FINAL PLAT STIMPLE SUBDIVISION FILING NO. 1

A PORTION OF SECTIONS 21 AND 22. TOWNSHIP 12 SOUTH, RANGE 65 WEST OF THE SIXTH PRINCIPAL MERIDIAN, EL PASO COUNTY, COLORADO

SHEET 1 OF 2
OCTOBER 3, 2024
JOB NO. 1185.80
STIMPLE SUBDIVISION FILING NO. 1

FINAL PLAT

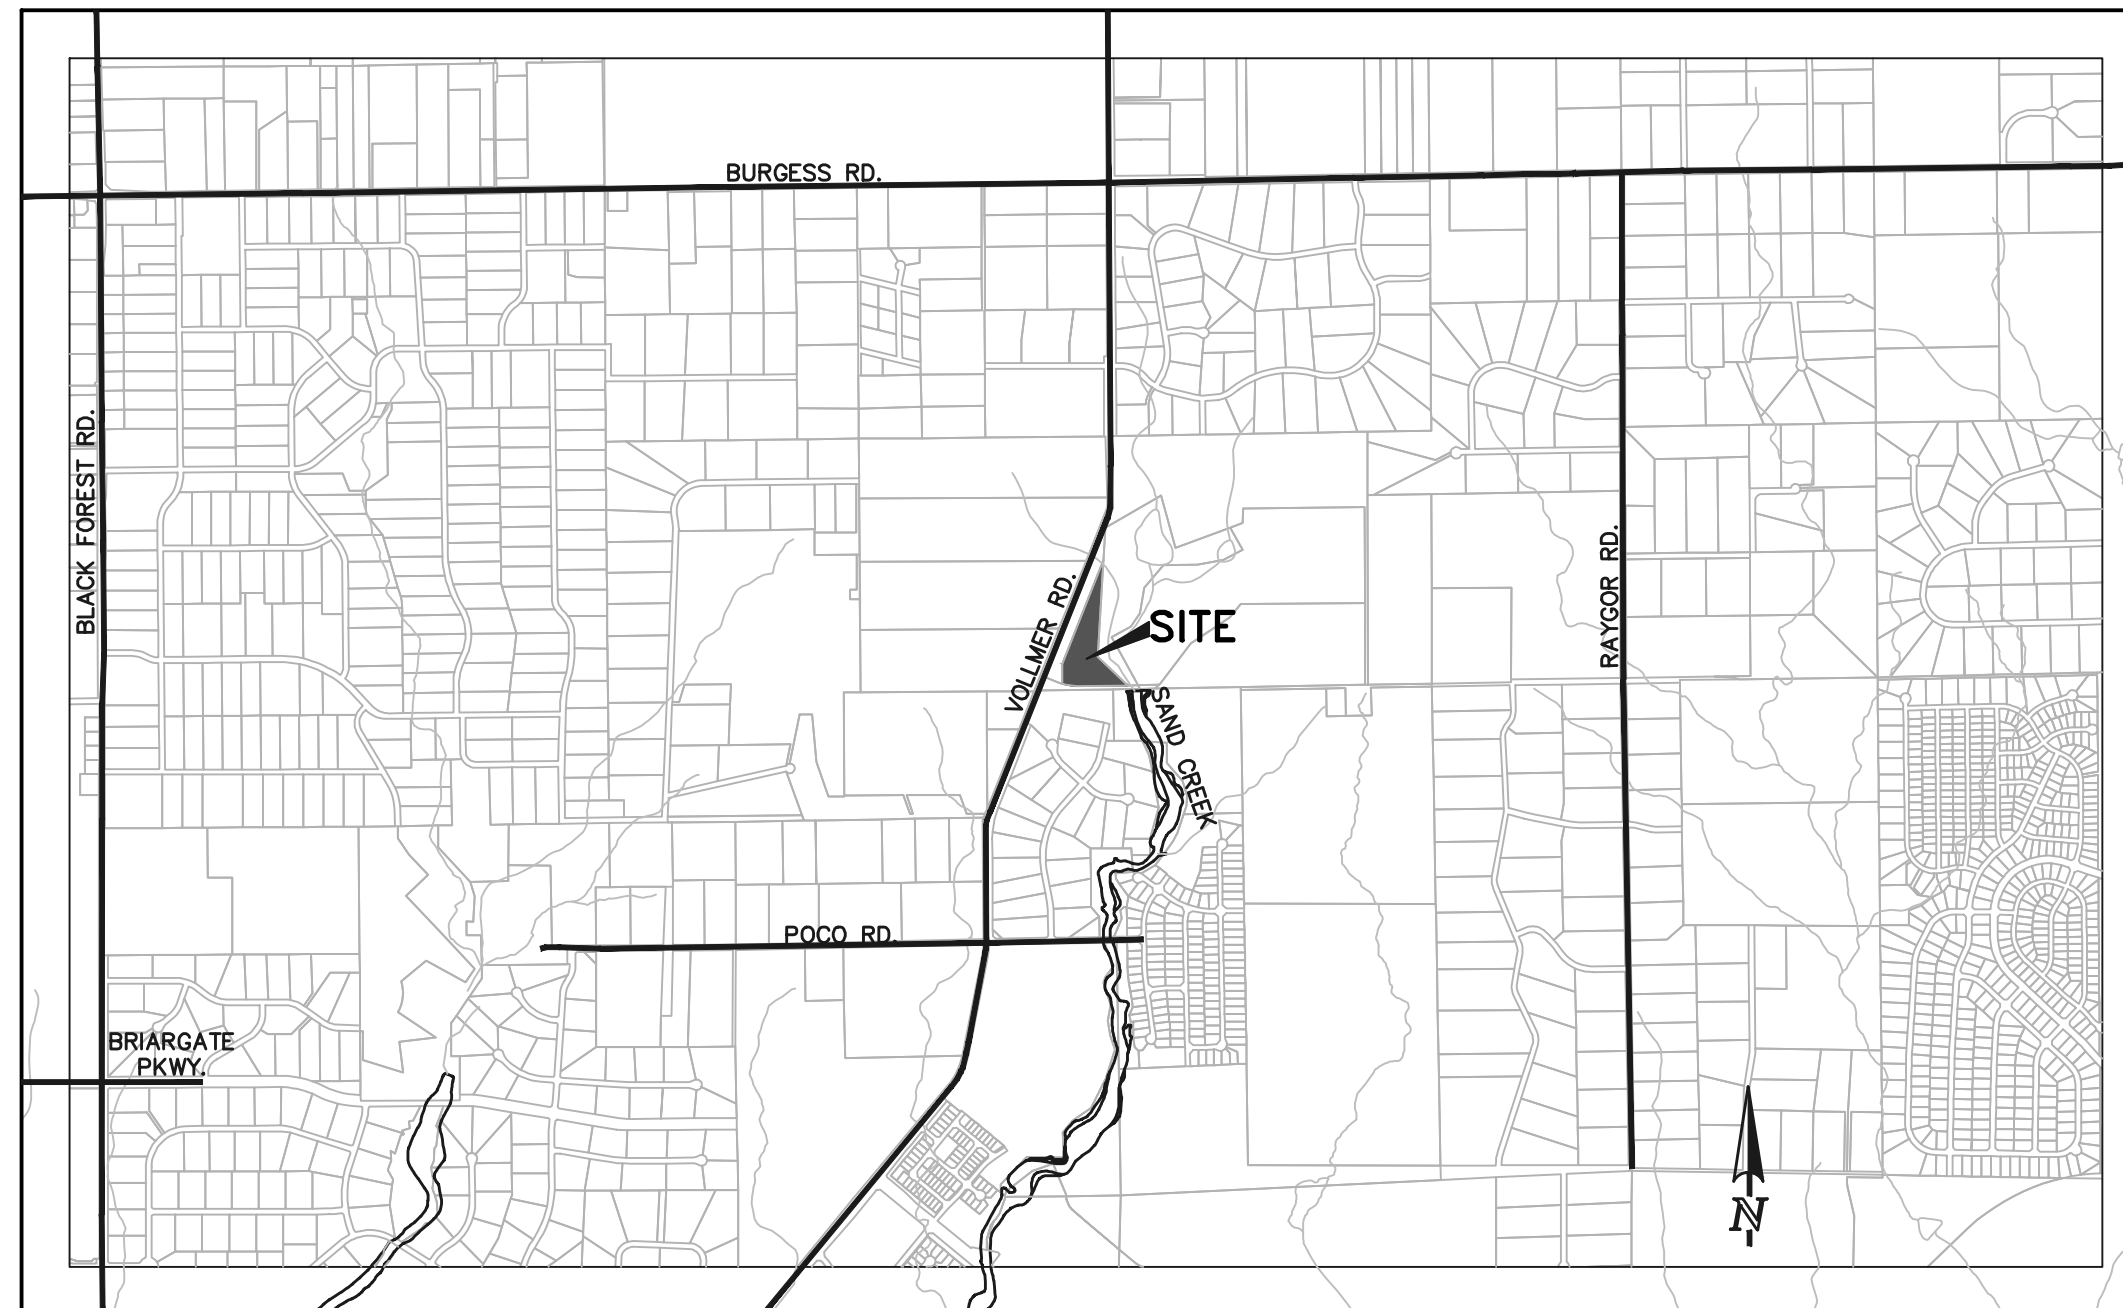
Remove.
THIS STICKER WILL BE REMOVED PRIOR TO MYLAR

Only regional park fees apply.

Address the following note from CGS on the plat:
3. Once the building location has been identified on Lot 1 and prior to the building permit application, a site-specific subsurface soil investigation consisting of drilling, sampling, lab testing, and analysis will be needed to characterize soil and bedrock engineering properties such as density, strength, water content, and swell/consolidation potential. These results will be required to evaluate potentially moisture-sensitive (expansive and collapsible) soils and expansive claystone bedrock; determine depths to groundwater and bedrock; verify the feasibility of a full-depth basement, if planned; and provide earthwork, foundation, floor system, surface and subsurface drainage, and pavement recommendations for design purposes.

REMOVED URBAN FEES AND FILLED IN OTHER FEES

ADDED A NEW NOTE RELATED TO CGS COMMENTS. SEE NEW NOTE 22.

FINAL PLAT STIMPLE SUBDIVISION FILING NO. 1

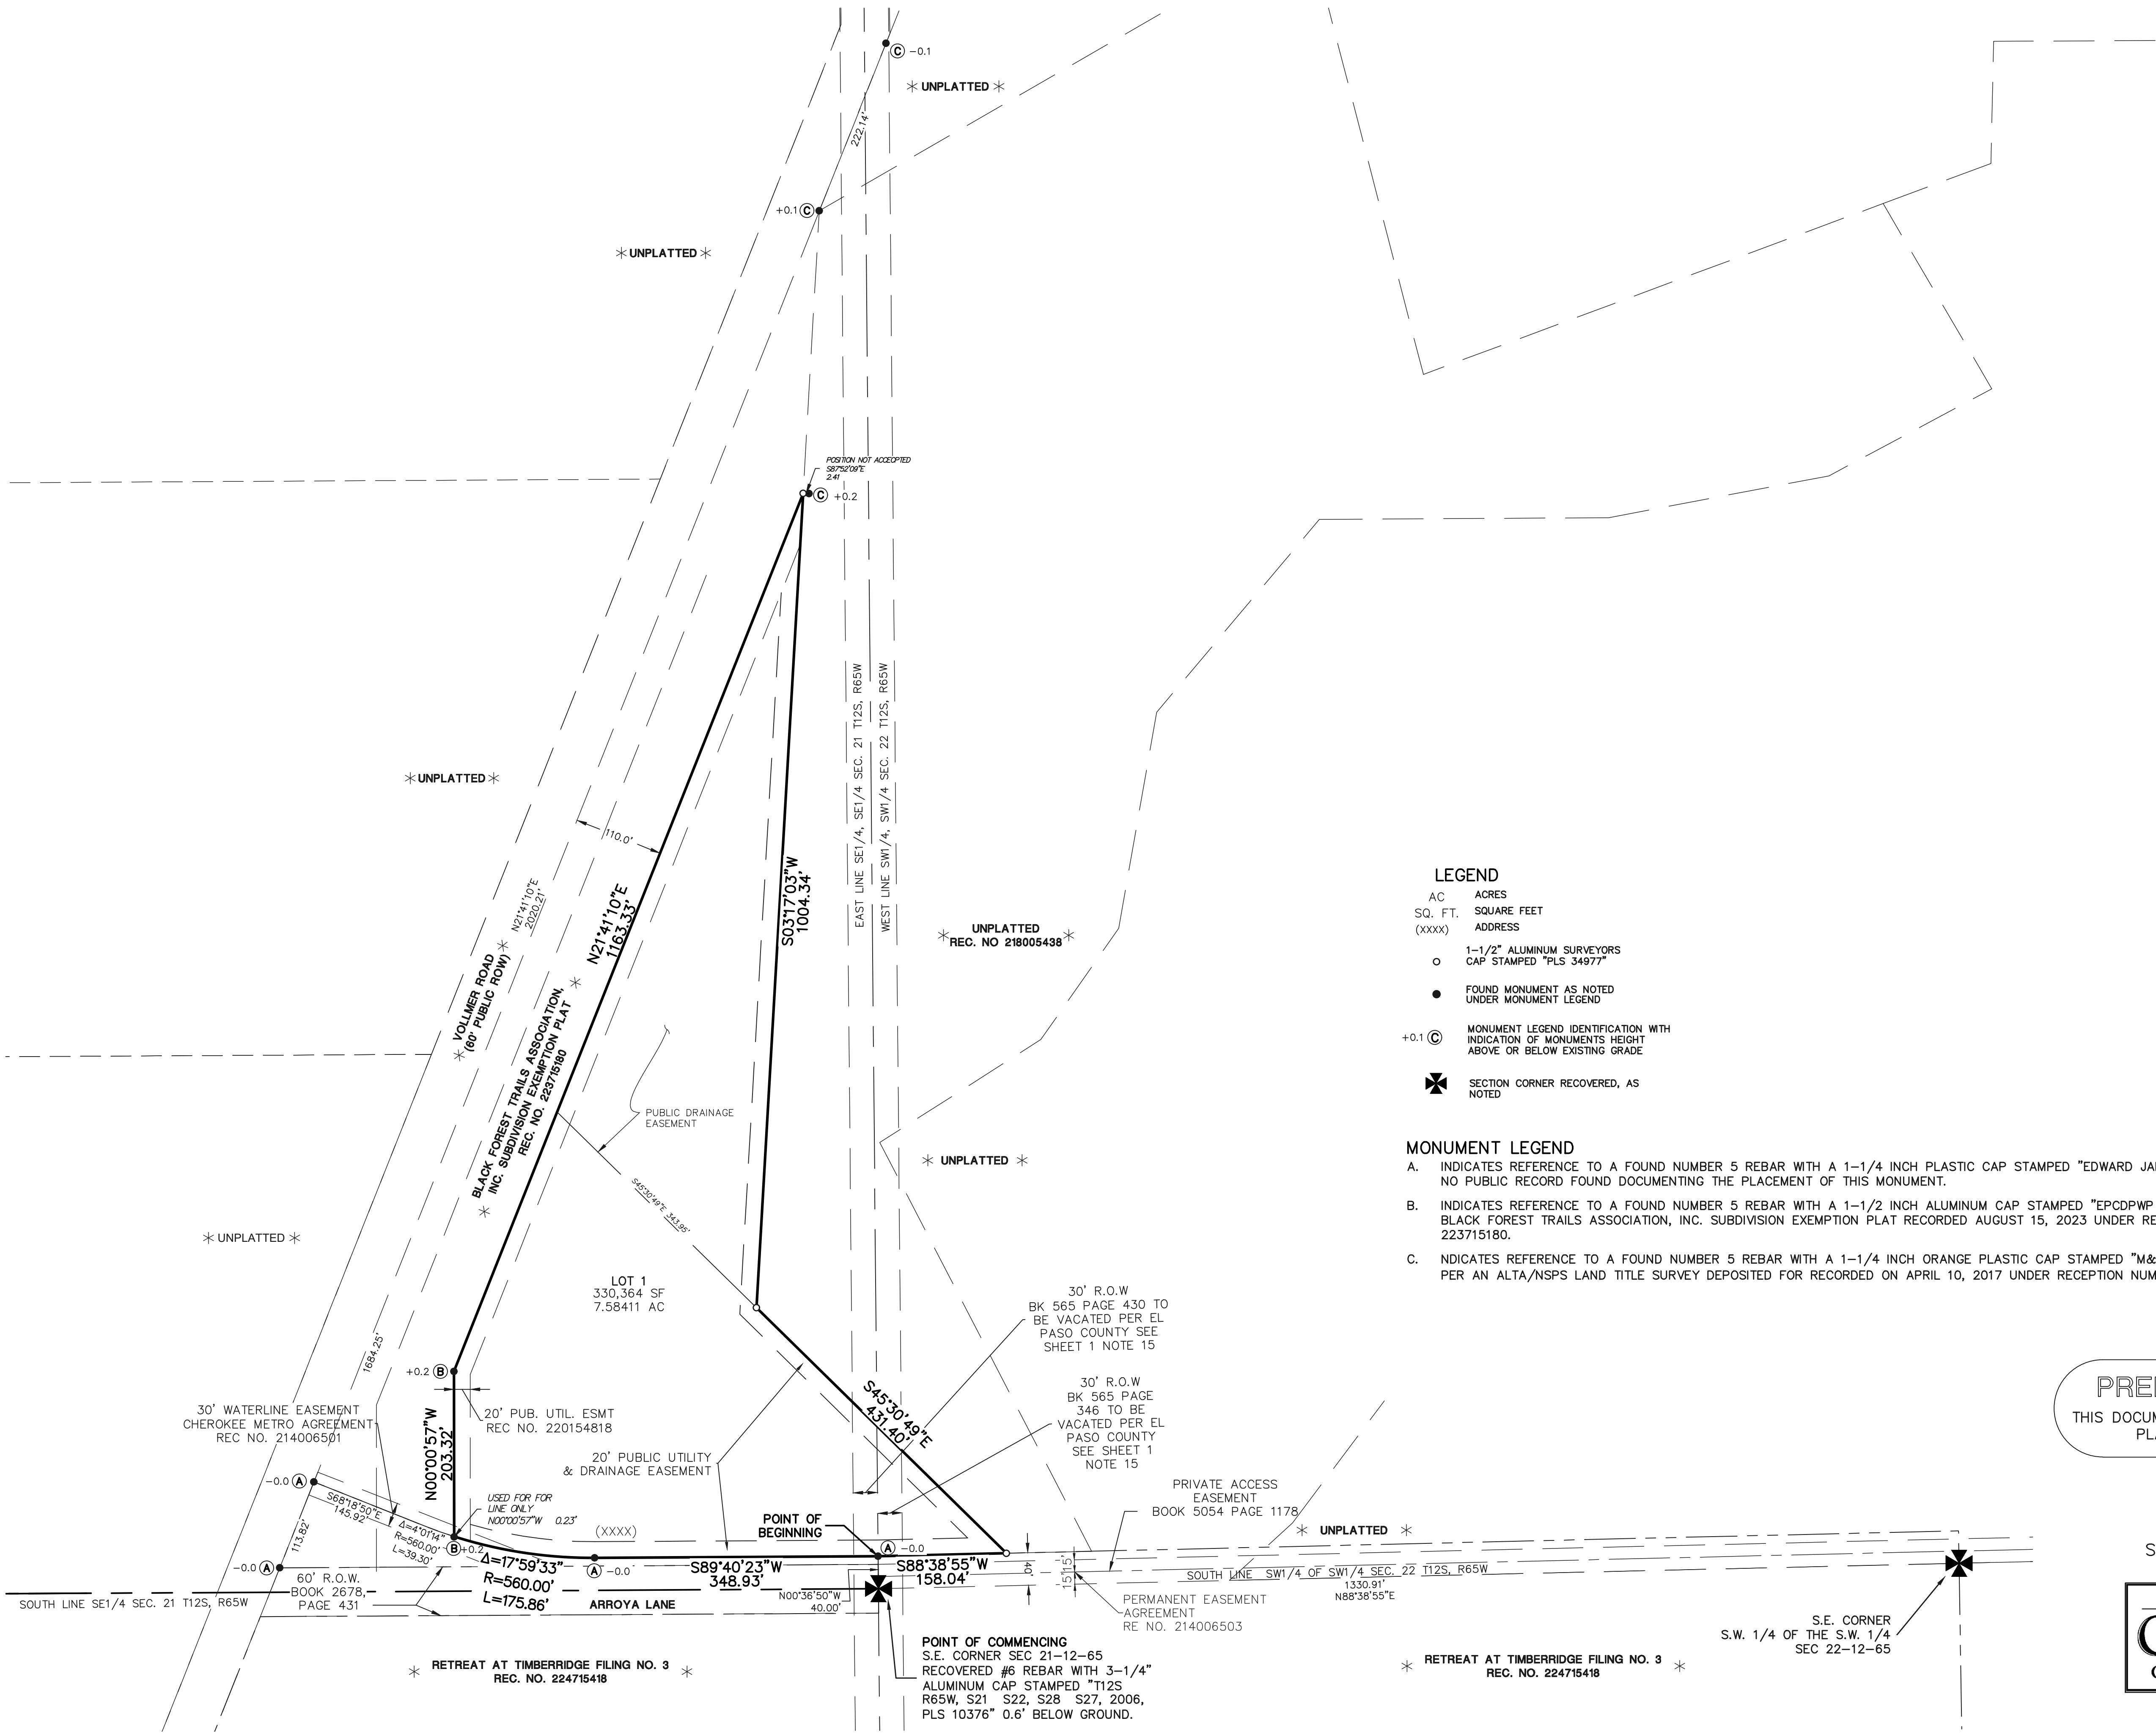
Per comment on previous plat submittal, please ensure that the Closure Sheet matches the bearings and lengths on the submitted plat, or provide reasoning as to why they should be allowed to differ.

Per comment on previous plat submittal, please ensure that the Closure Sheet matches the bearings and lengths on the submitted plat, or provide reasoning as to why they should be allowed to differ.

PLEASE SEE UPDATED CLOSURE

PLEASE SEE UPDATED CLOSURE
